From: James Kenny [REDACTED]
Sent: 11 November 2021 16:11
To: Amy Myer <Amy.Myer@arun.gov.uk>
Subject: RE: FG/142/21/PL - Land N Highdown Vineyard - COMMENTS REQUIRED URGENT PLEASE

I went and had a look this morning and took the attached photograph from the top of the rampart of the Scheduled hillfort. The application site may be just visible (somewhere in the vicinity of the red rectangle I've superimposed) from the top of the rampart of the hillfort near its centre, but isn't at all from anywhere within it and is obscured by the slope of the hill from anywhere below (outside of the rampart). In my opinion the effects of the proposed development on the setting of the monument would be less than

Client		
Mark Wood, Premier by Design Ltd		
Project Title		
Drawing Title		
Container Details		
Scale @ A3 1:50	Amended by: MA	Date 31.07.2021
Drawing Number 201		Revision

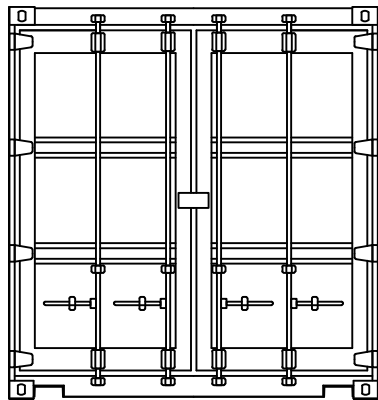
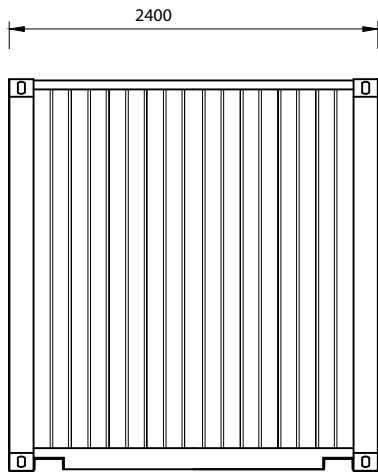
substantial. If the containers and fence were to be painted dark green they would probably be barely noticeable amongst the existing trees and hedges.
